KITTITAS COUNTY FIRE MARSHAL'S OFFICE

July 2, 2013

Re: Buress (BL-13-00012)

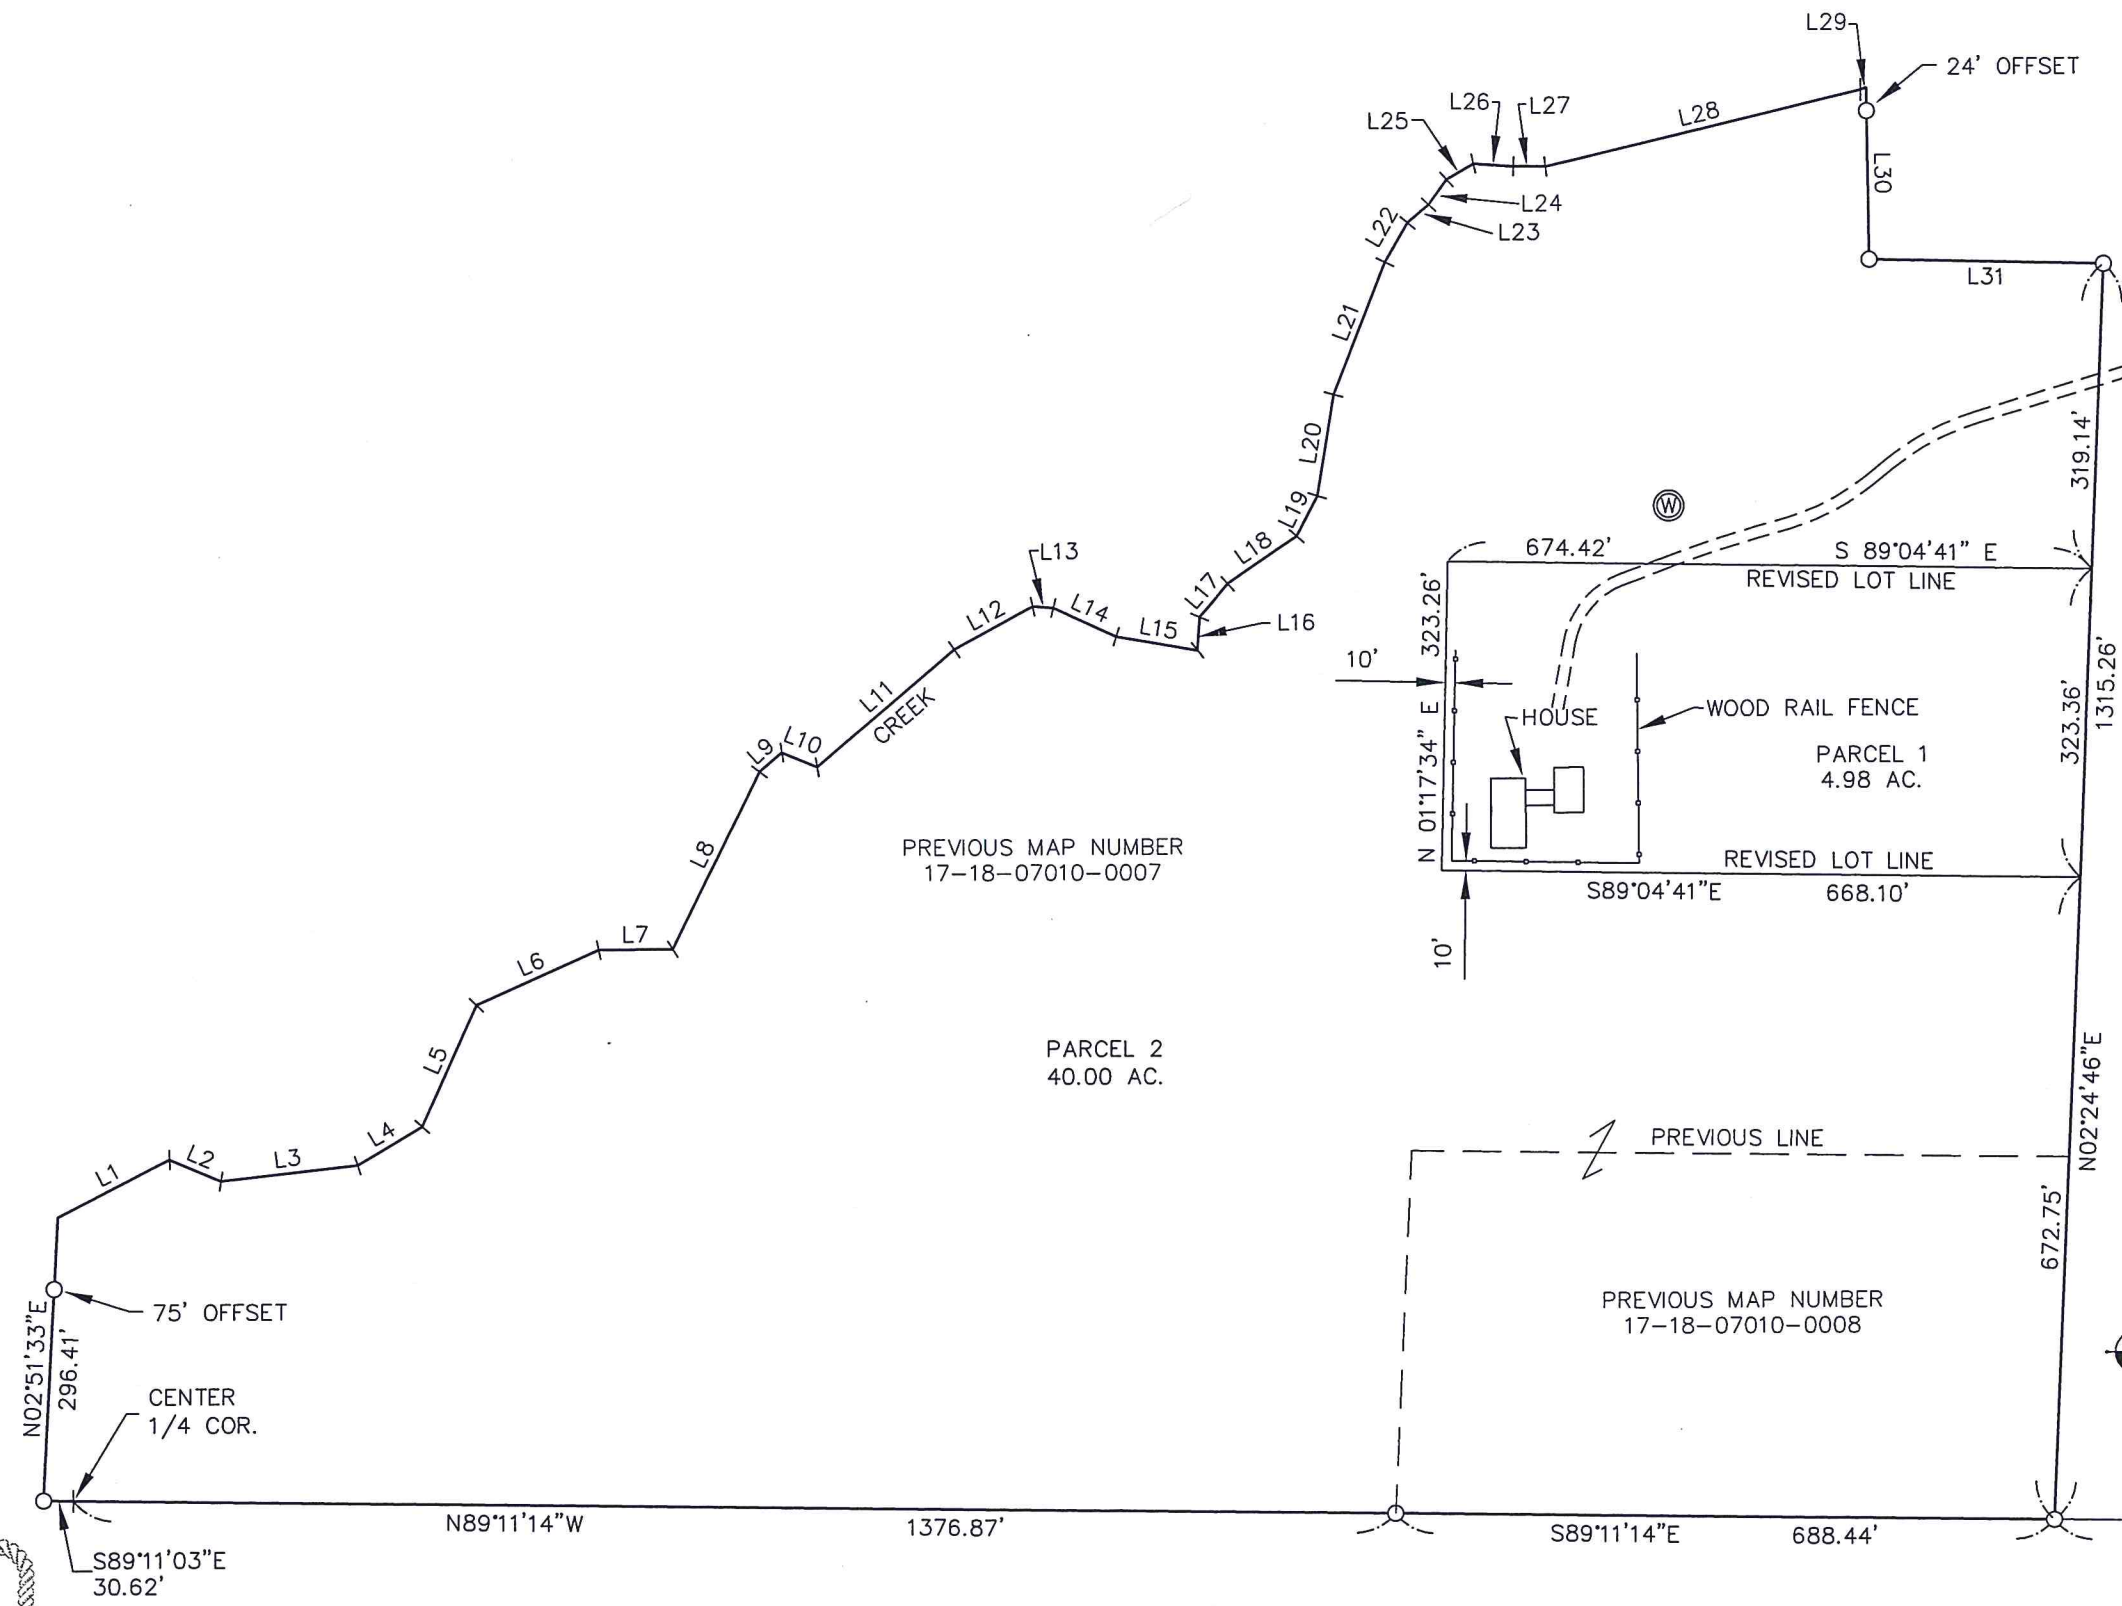
- Ensure that boundary line adjustments do not infringe upon existing structures, to include propane tanks, etc.
- Ensure adequate access for fire apparatus. Any driveways or access points created based off the new lot configurations shall comply with Kittitas County Code 20.02.030.
- All future development must comply with the International Fire Code.
